I am writing on behalf of the British Horse Society (BHS) a membership charity with over **125,000** members representing the UK's **3 million** regular riders and carriage drivers, in response to the Light Valley Solar Ltd Project. The BHS is the largest and most influential equestrian charity in the country, working to improve the lives of horses and their owners through its four core foundations of education, welfare, safety and access.

**The BHS objects to the DCO.** The BHS objects to this application on the grounds that the application does not meet the tests of NPPF Paragraph 105. The BHS objects on the grounds that equestrians are being marginalised in the scheme with walkers and cyclists being favoured. Throughout this scheme equestrians are excluded, the arguments for inclusivity of walkers and cyclists can be extended to equestrians using the mechanism of the Equality Duty. This is a form of discrimination, and the Equality Act 2010 created a Public Sector Equality Duty for authorities to provide equal opportunities for all, which means that an authority needs a cogent reason for excluding equestrians.

Drawing Title  
**Figure 13.3**  
**Public Rights of Way and Permissive Paths**  
**Enhancements and Diversions**  
**Sheet Number 1 of 9**

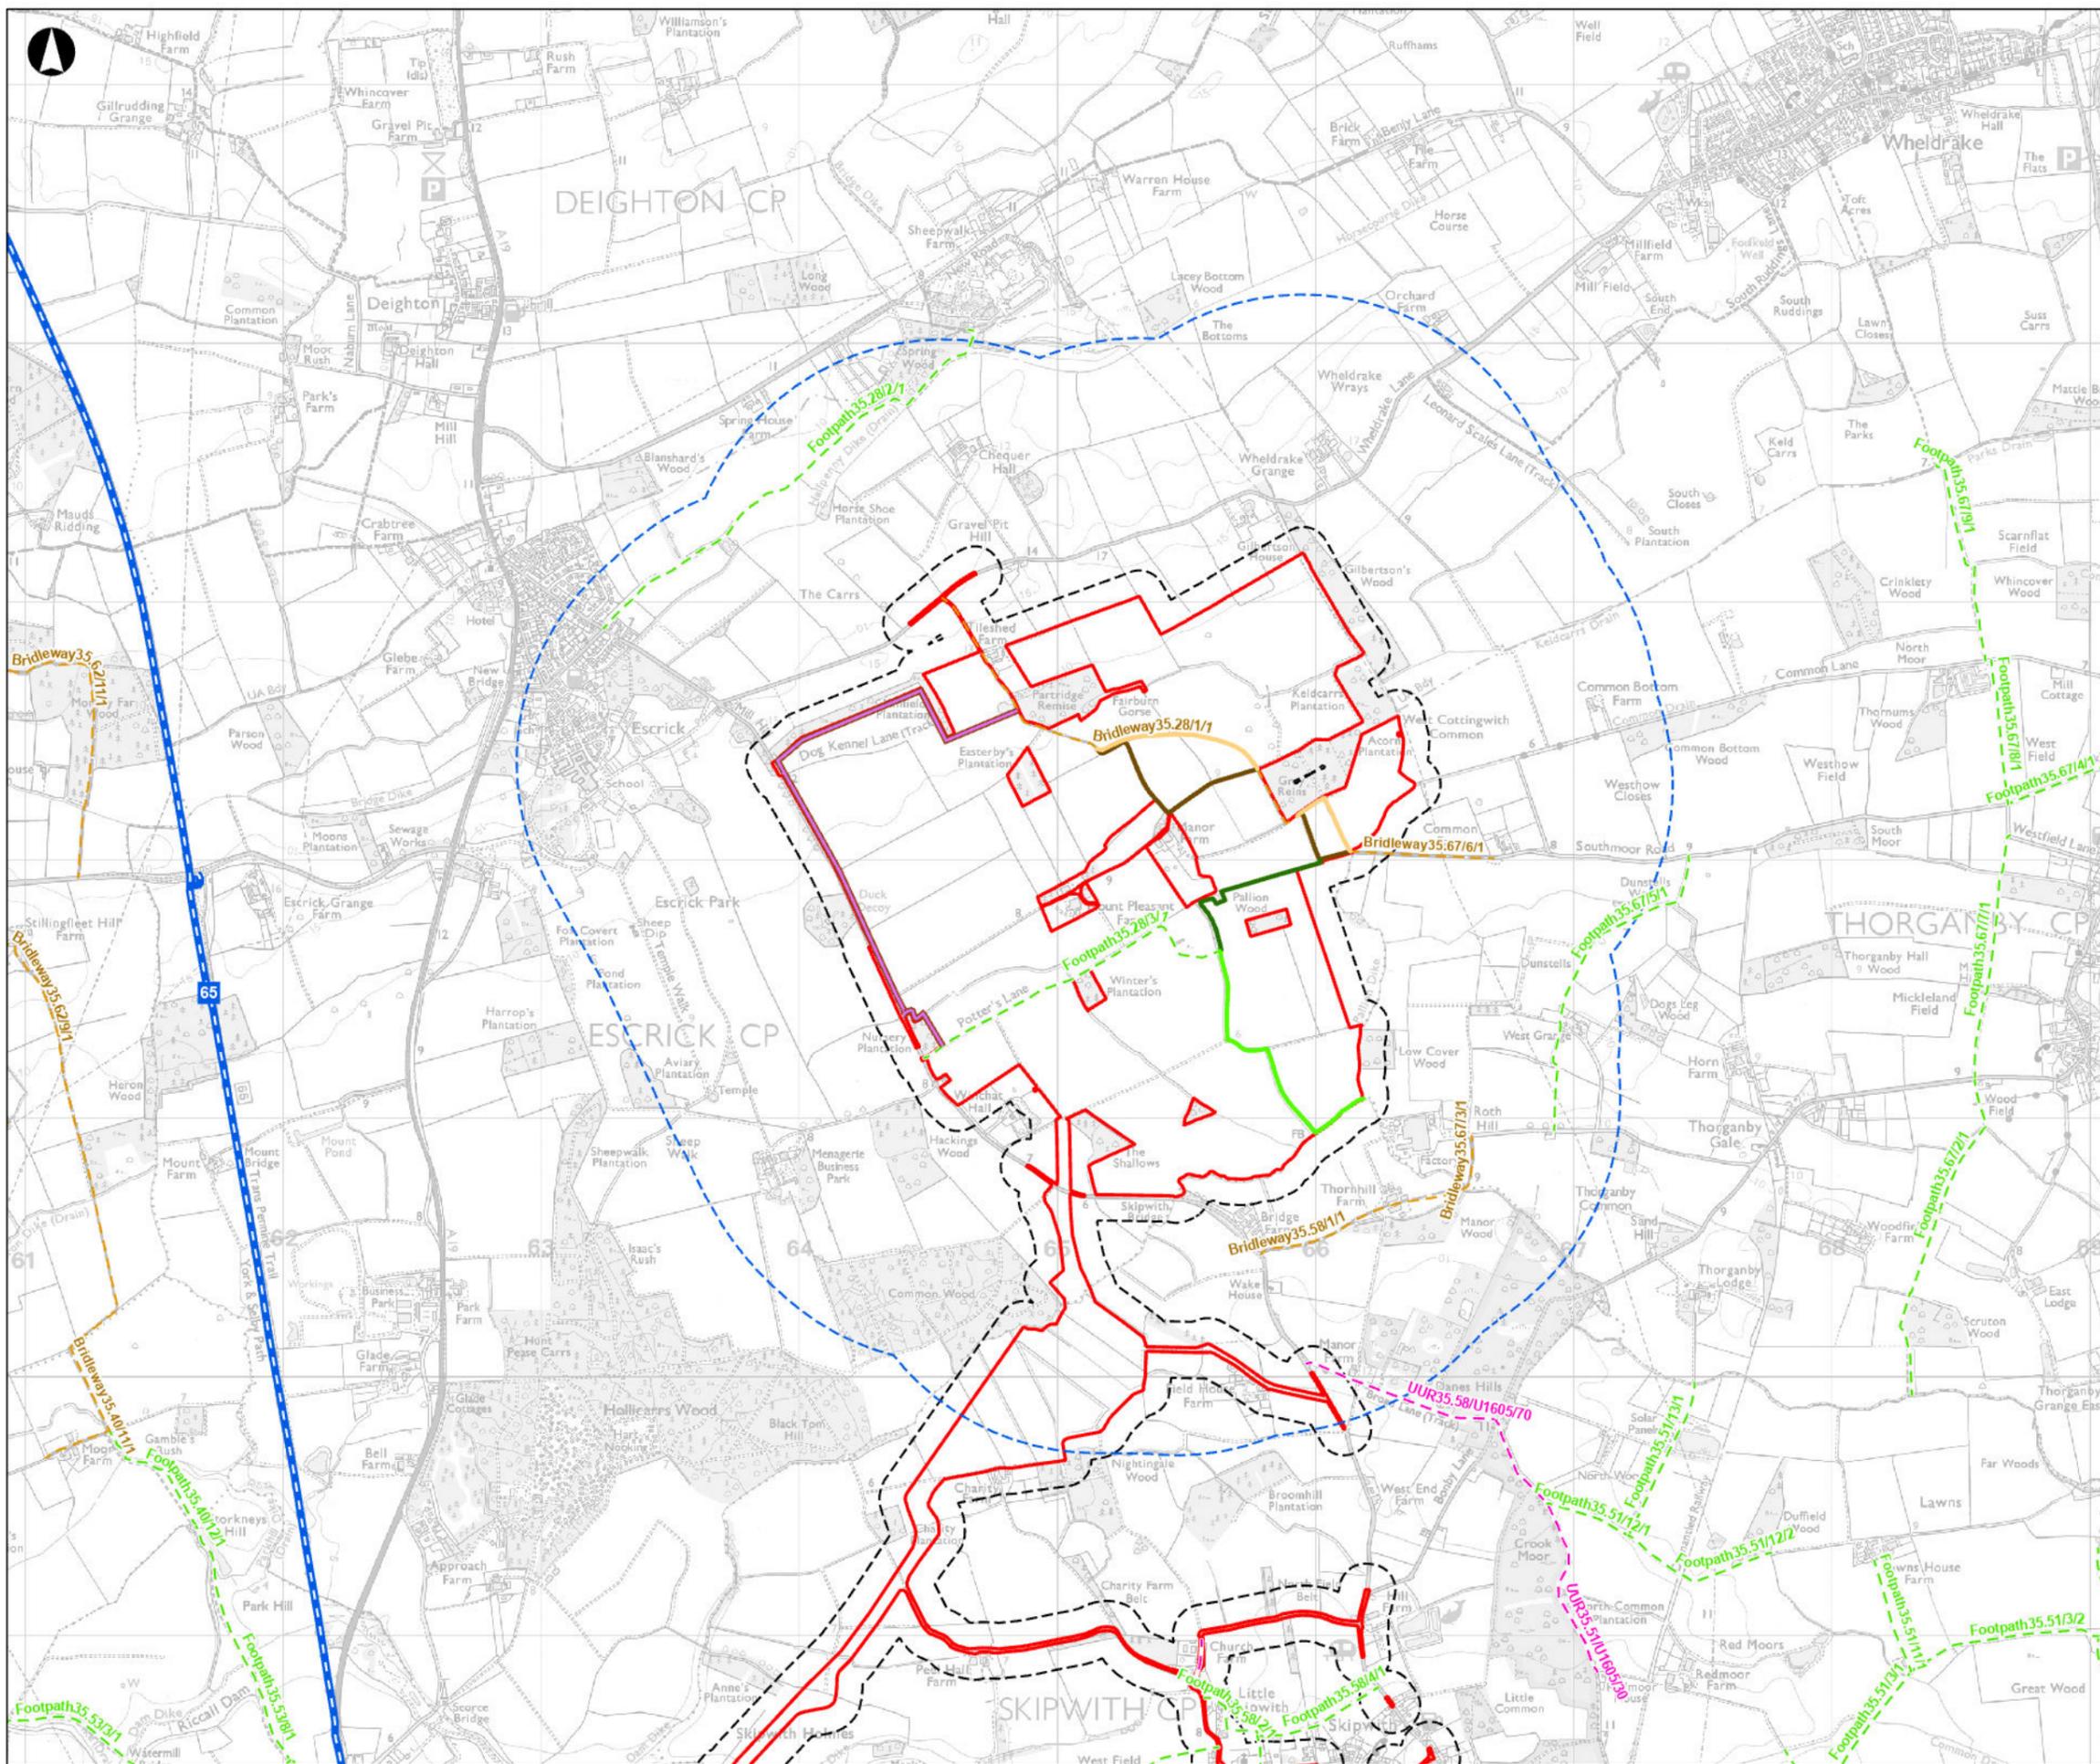
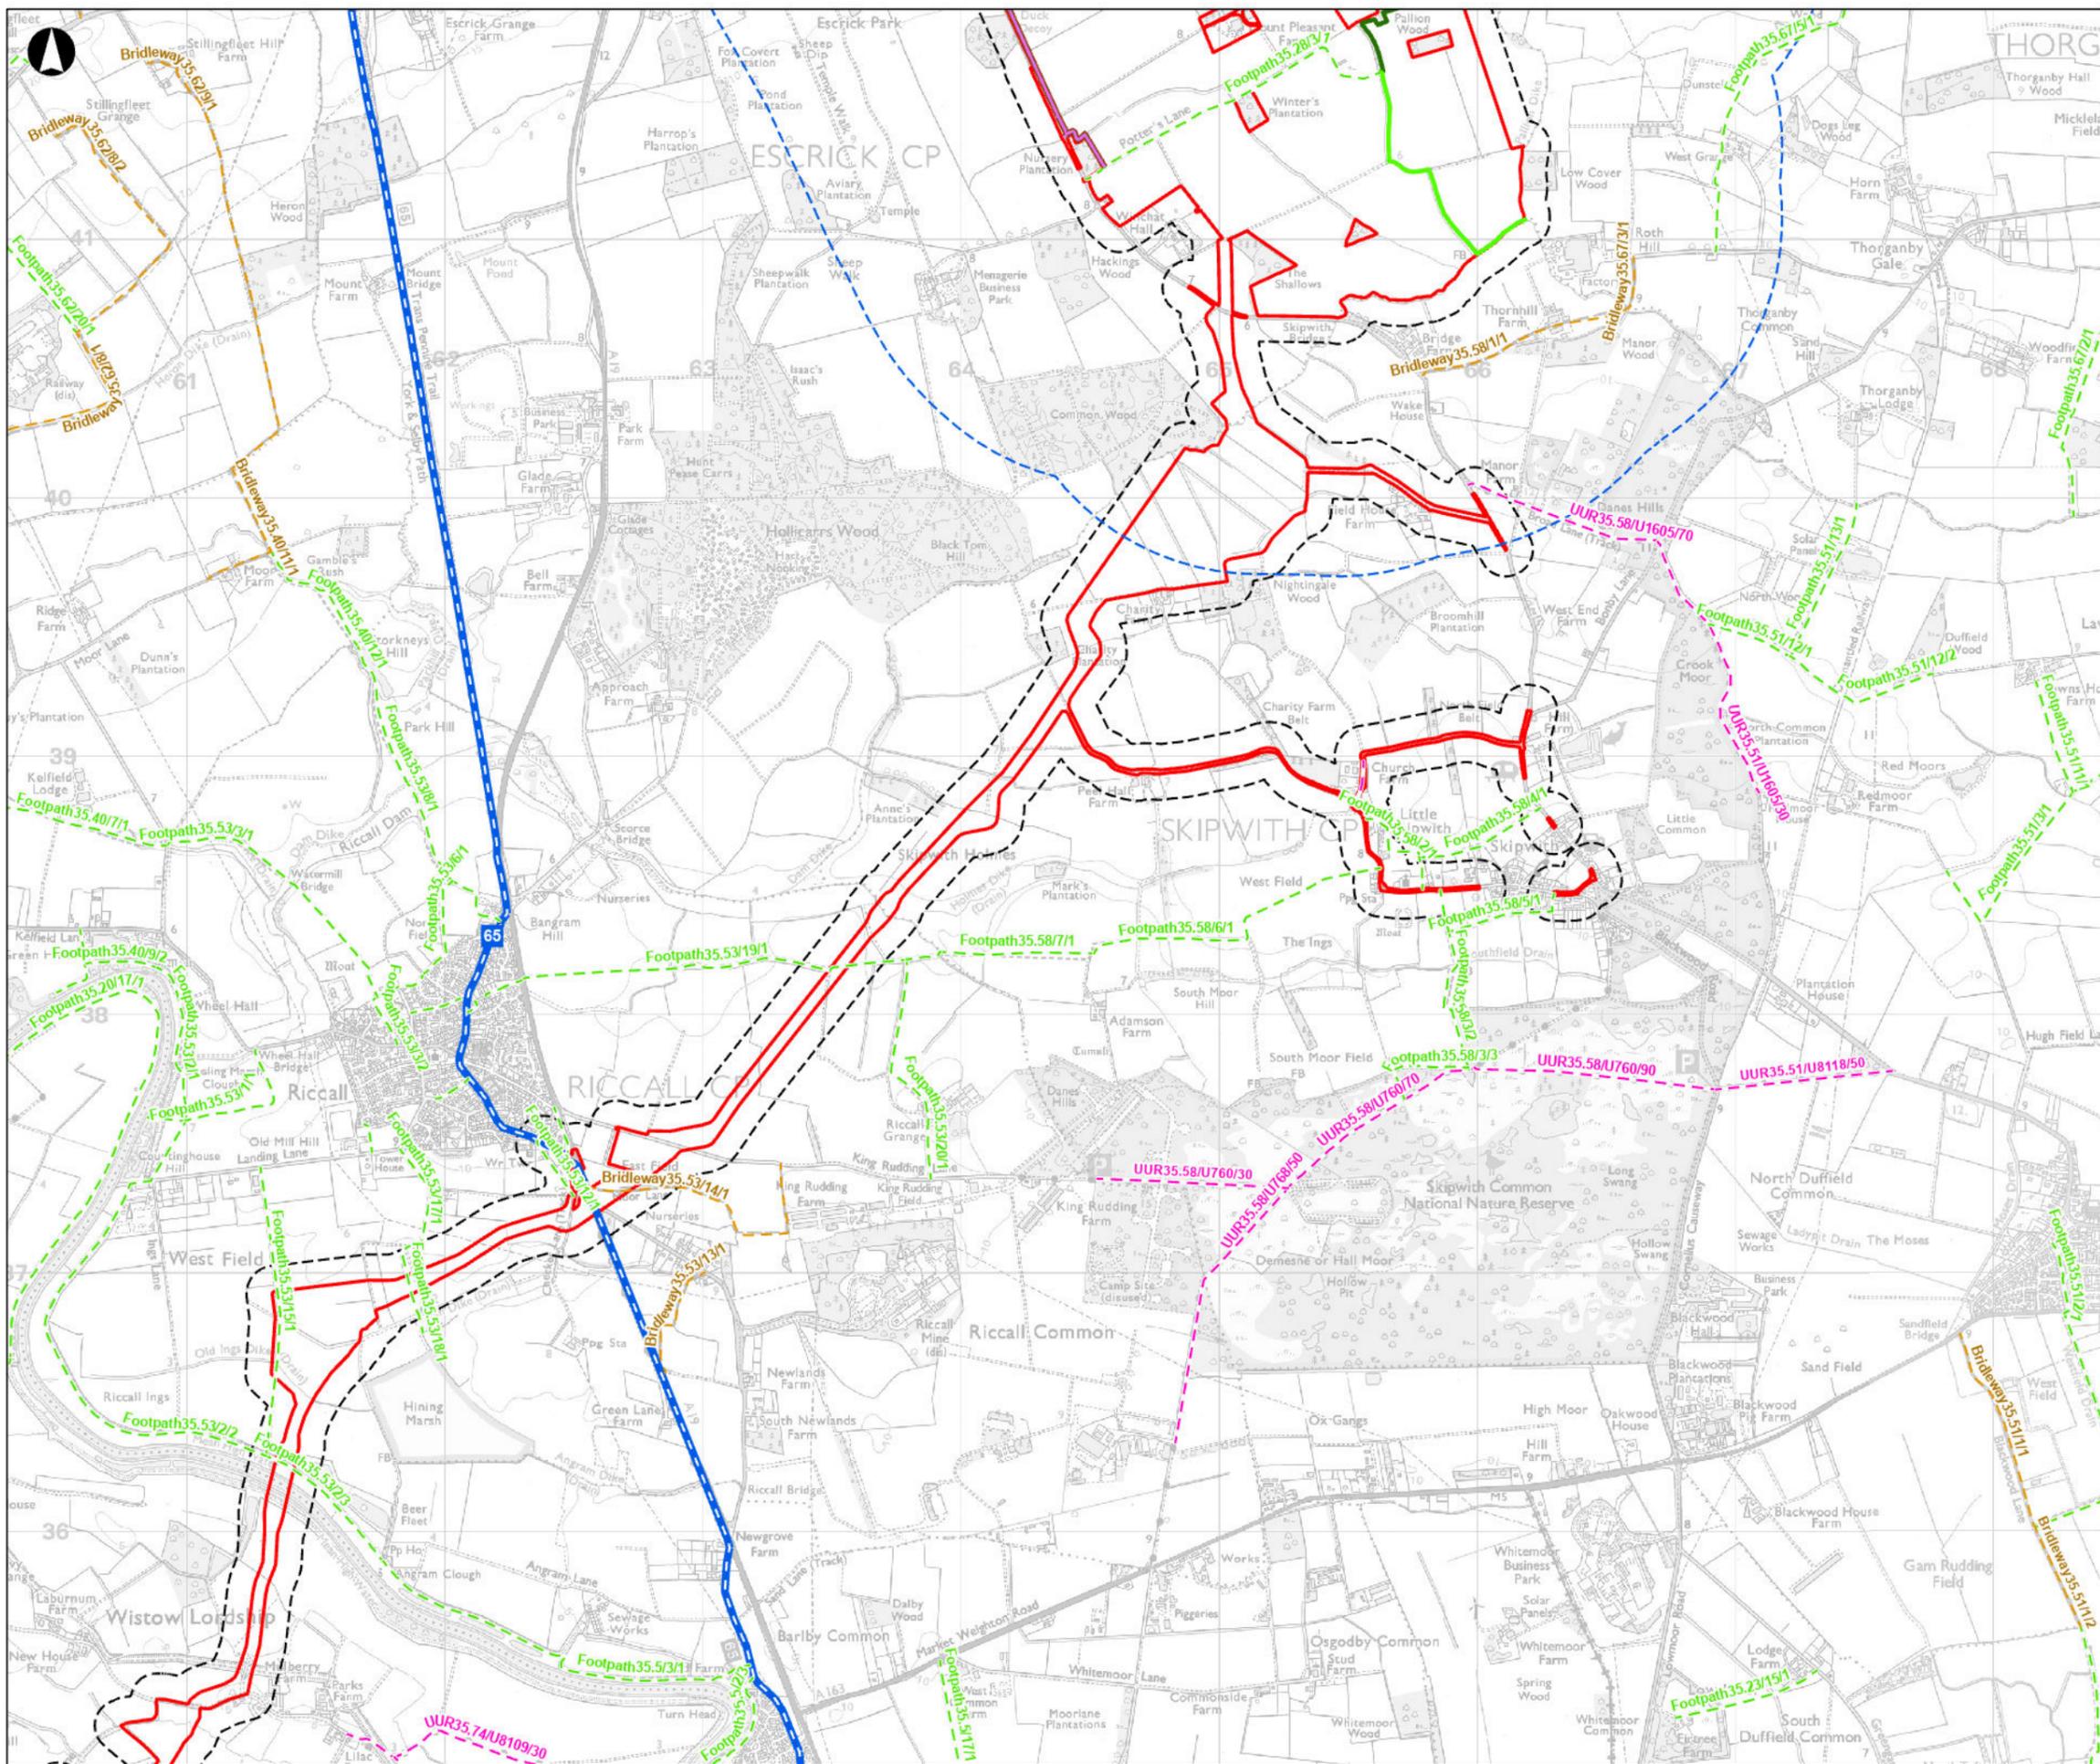
Permissive paths should be multi-user and made available for all NMU users not just walkers and cyclists it should be noted that cyclists can legally use bridleways it therefore makes more sense that these permissive paths be multi-user.

The distances of Permissive paths within the scheme are shown as a mere 8km which does not seem appropriate for a scheme of this size. We would like to see the distances available to each user group broken down by length, IE permissive path length available to Pedestrians separated from both cyclists and horse riders.
